Job No. 180213

June 29, 2023

Re: Response to CGS Comments  
16975 Falcon Highway  
El Paso County, Colorado

EXHIBIT "A" SITE PLAN

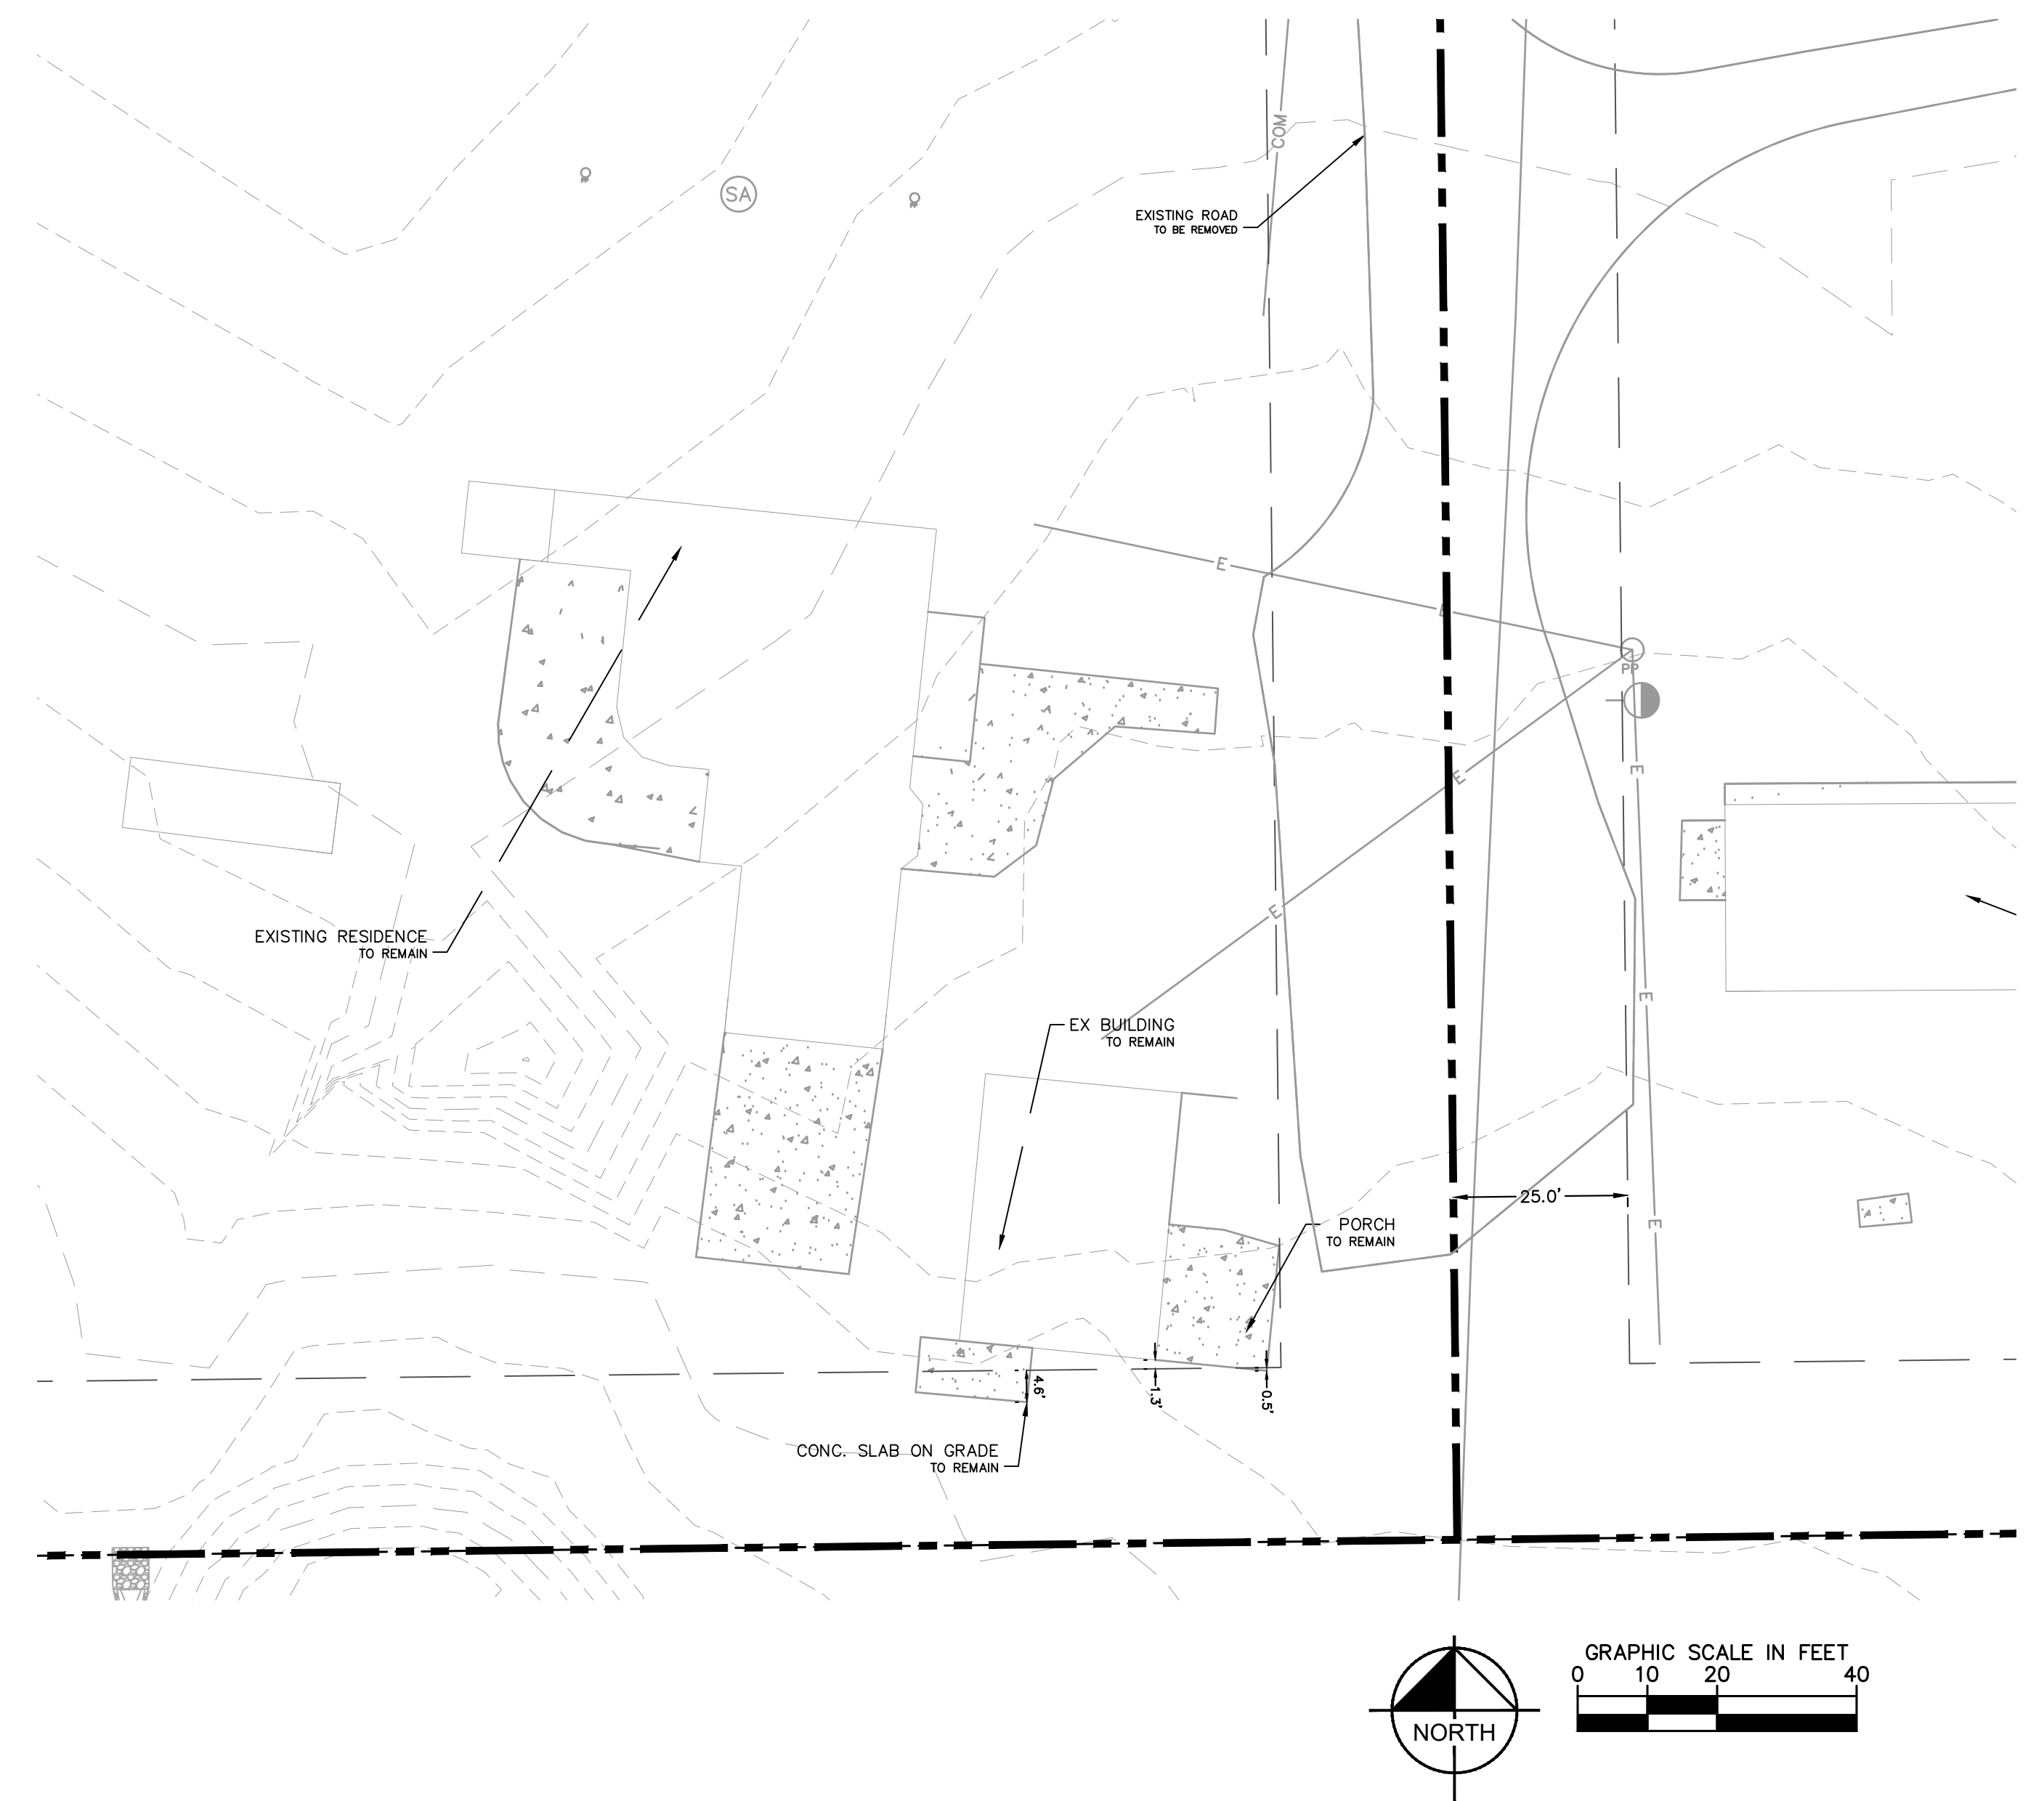
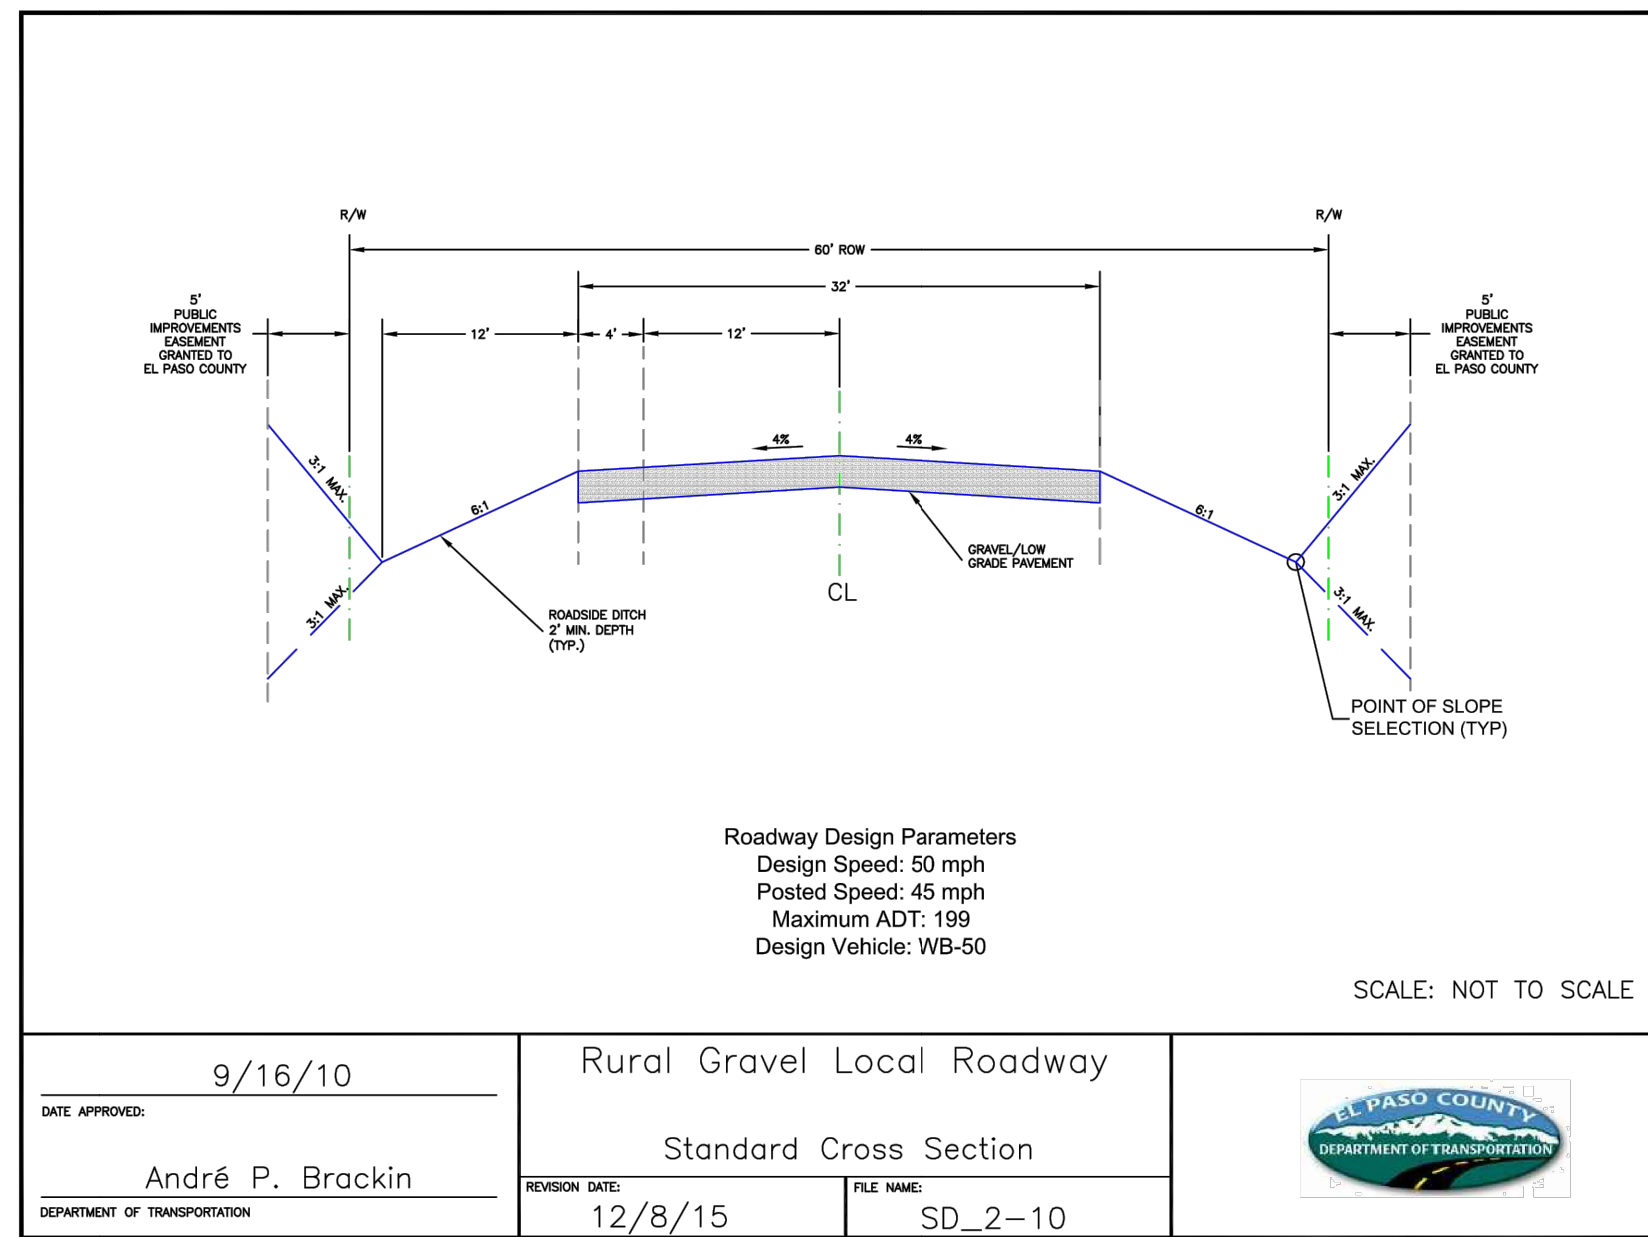
The Preliminary Plan (Kimley Horn, printed 12.21.21) includes a good note about potential geologic impacts on development. It would be prudent for the county to require an additional note on the plan that basements or crawlspaces are not allowed without data demonstrating adequate separation (approximately 3-5 feet) can be maintained from fluctuating groundwater levels. An unconfined aquifer was encountered in the subsurface investigation. RMG's report has gathered data at a specific time (in this case March, considered a seasonally low point in groundwater levels). This data is a "snapshot" of groundwater depth. No data is presented on the extent of groundwater fluctuation either seasonally or from year to year. Basements should not be allowed without groundwater monitoring throughout a 12-month period that clearly indicates adequate separation (approximately 3-5 feet) can be maintained from fluctuating groundwater levels. Impacts to the measured fluctuating groundwater levels from variations in yearly precipitation rates must be included in this analysis. Prior to approval of basement or other habitable below-grade construction site-specific investigations must provide data on the fluctuation of groundwater and how the variation of yearly precipitation rates may impact this fluctuation. All RMG's recommendations, and specifically ones concerning drains, should be strictly adhered to.

Based on our review, we concur that the feasibility of basement construction should be evaluated on some of the included lots. Our recommendations are as follows:

Proposed Lots 1, 5, and 6:

If basements are proposed on lots 1, 5, and/or 6, basement construction should be restricted on lots 1, 5, and 6 *except* where one of the following conditions apply:

- A year-long groundwater monitoring study is undertaken, and the results indicate that groundwater is sufficiently deep to allow basement construction;
- The proposed construction will result in at least 15 feet of separation between the proposed ground surface and the groundwater elevation. Where groundwater encroaches shallower than 15 feet, the ground surface may be modified (raised) to increase the separation to meet these criteria.

If groundwater is encountered at the time of the site-specific subsurface soil investigations within 4 to 6 feet of the proposed basement slab elevation, an underslab drain should be considered in addition to the perimeter drain. It must be understood that subsurface drains are designed to intercept some types of subsurface moisture and not others. Therefore, the drain(s) could operate properly and not mitigate all moisture problems relating to foundation performance or moisture intrusion into the basement area.

Proposed Lots 2, 4, and 7:

Based on the currently proposed building locations on lots 2, 4, and 7, it is our opinion that the proposed structures will have adequate separation from groundwater. We do not recommend that a basement feasibility study be required on lots 2, 4, or 7 provided that the

future structures are located in the eastern 1/2 of lots 2 and 4 or the eastern 2/3 of lot 7. If basement construction is proposed on the western portions of these three lots in the future, we recommend that those structures be subject to the same feasibility evaluations as recommended above for lots 1, 5, and 6.

Proposed Lot 3:

New construction is not currently proposed on lot 3. If basement construction is proposed on lot 3 in the future, we recommend that those structures be subject to the same feasibility evaluations as recommended above for lots 1, 5, and 6.
